SECTION 75 W APPLICATION - ACCESSIBILITY REVIEW

Commercial and Retail Development

100 Mount Street, North Sydney

Date: 19th August 2011

scale 1:400 @ A3, 1:200 @ A1 drawing no.  
drawn **DA141**  
checked MC issue  
project no 110059 **B**

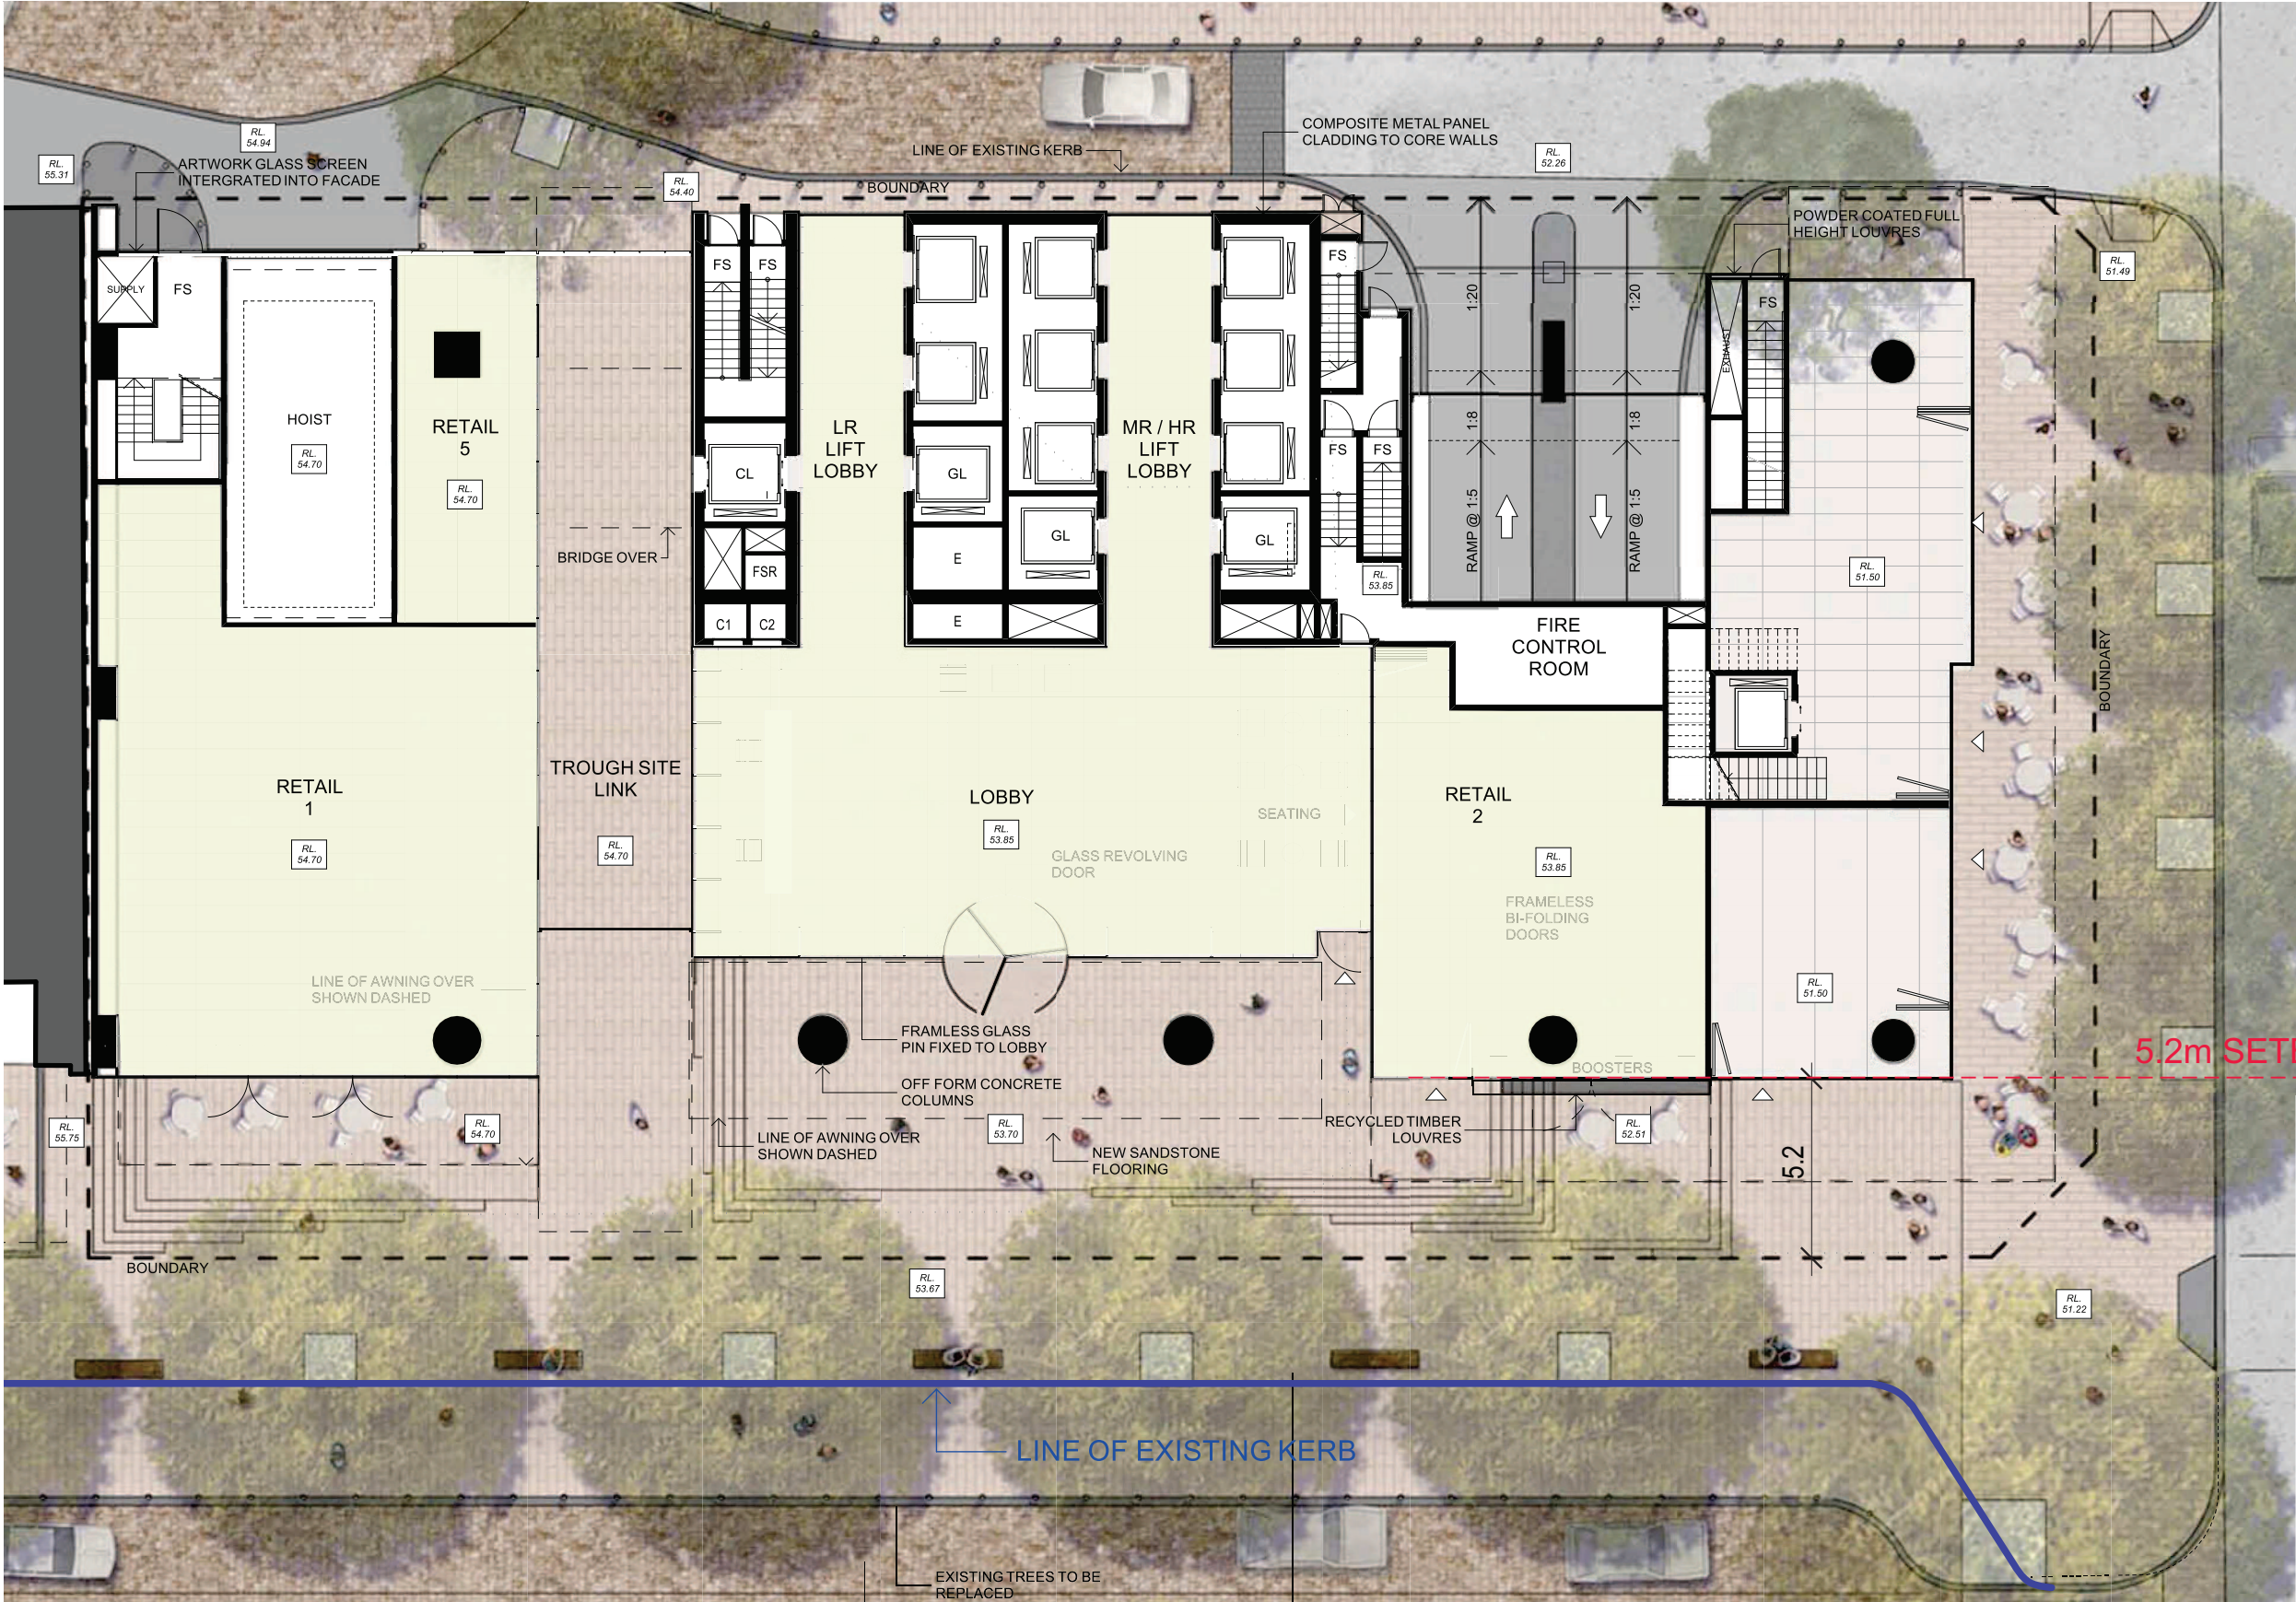
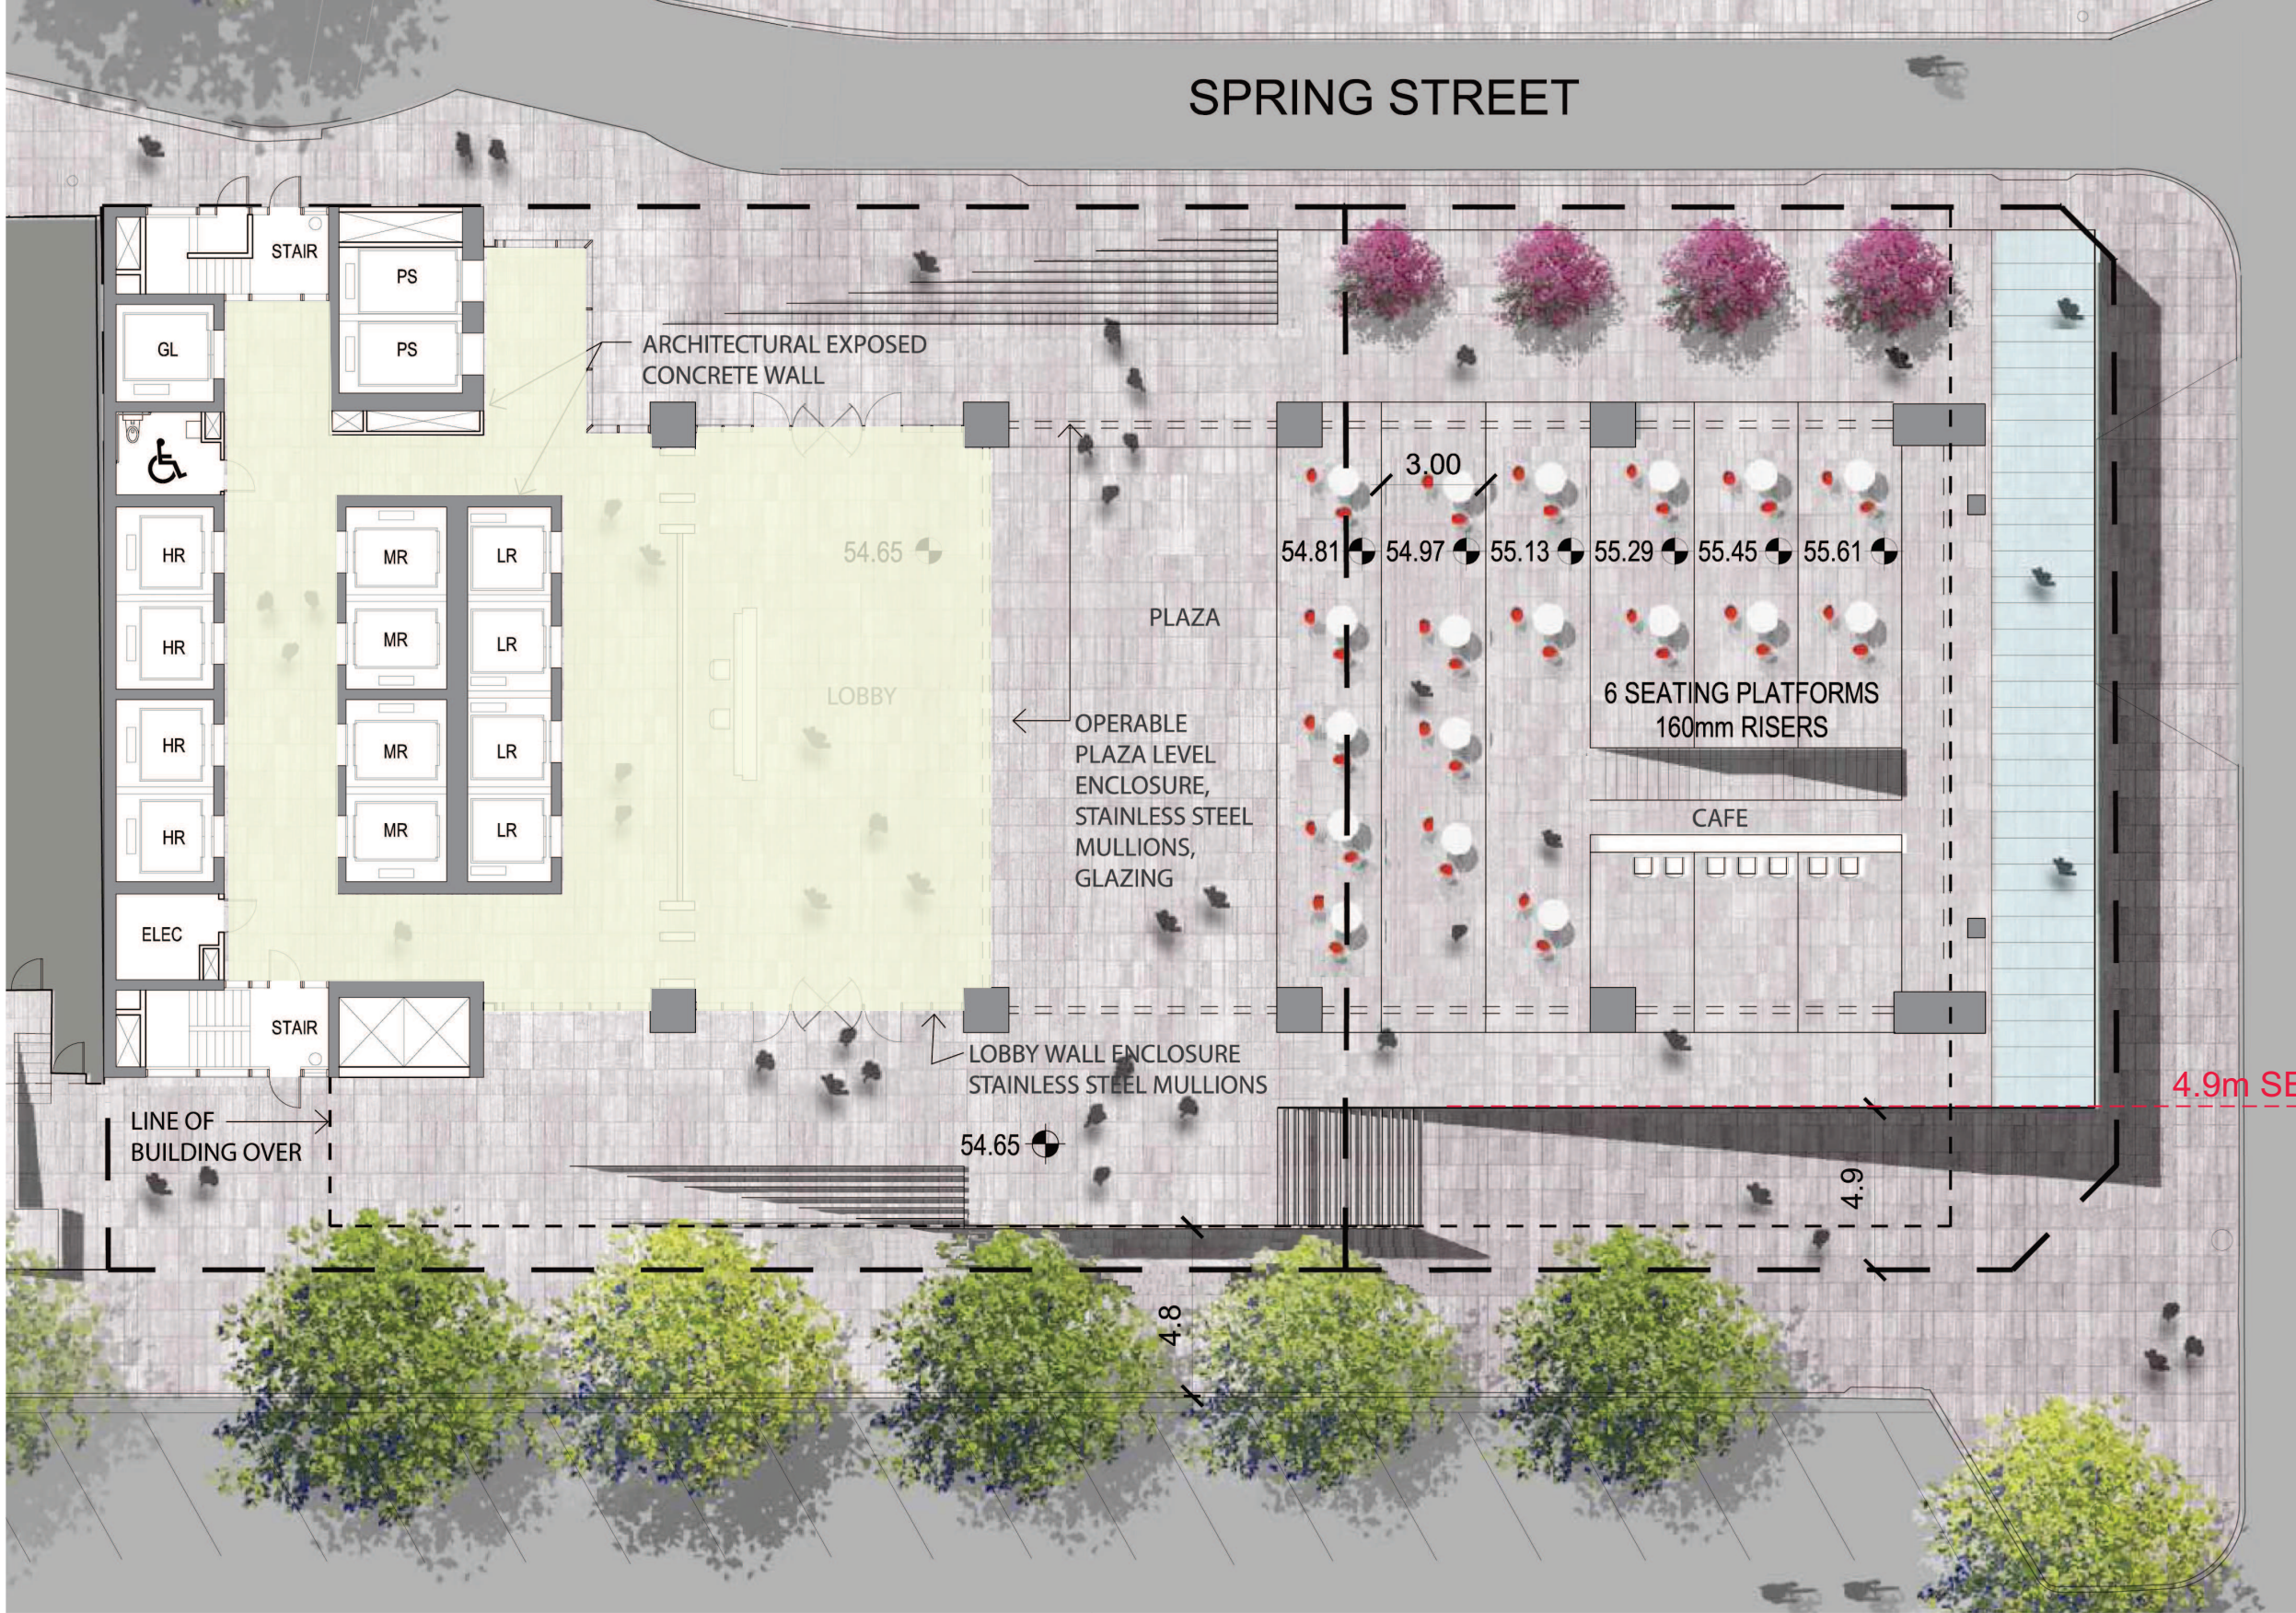
- The existing topography of the site may limit access by people with disabilities between the Walker Street retail entrance and Ground Level entrances.
- The proposed transition between the ramped external walkways on either side of the building (North and South) and the seating platforms requires confirmation.
- The crossfall of the external pathways is yet to be confirmed.
- The location of drainage pits to be confirmed.
- Limited documentation has been provided regarding proposed external finishes.

- The provision of stairs only limits access between Ground Floor and the Retail Level. However, it is understood at this stage that the spaces will operate as separate venues with access for service staff only.
- There is limited access to the raised seating platforms located on Ground Floor.
- The proposed clearance widths to the secured entry at Ground Floor requires confirmation.

- 4.2.1 Further discussion is required as the designs progress in order to specify the relationship between the Ground Floor and the Retail Level to ensure access for people with disabilities is provided as required.

- 4.3.1 Further discussion is required as the designs progress in order to specify the function of the proposed stair between Ground Floor and the Retail Level, including suitability for access by service staff only.
- 4.3.2 Develop ramped access to the raised seating platforms. This may be achieved by the incorporation of a mid-landing to the proposed external ramps.
- 4.3.3 Confirm a minimum clearance of 1000mm to not less than one secured entry at the Ground Floor.
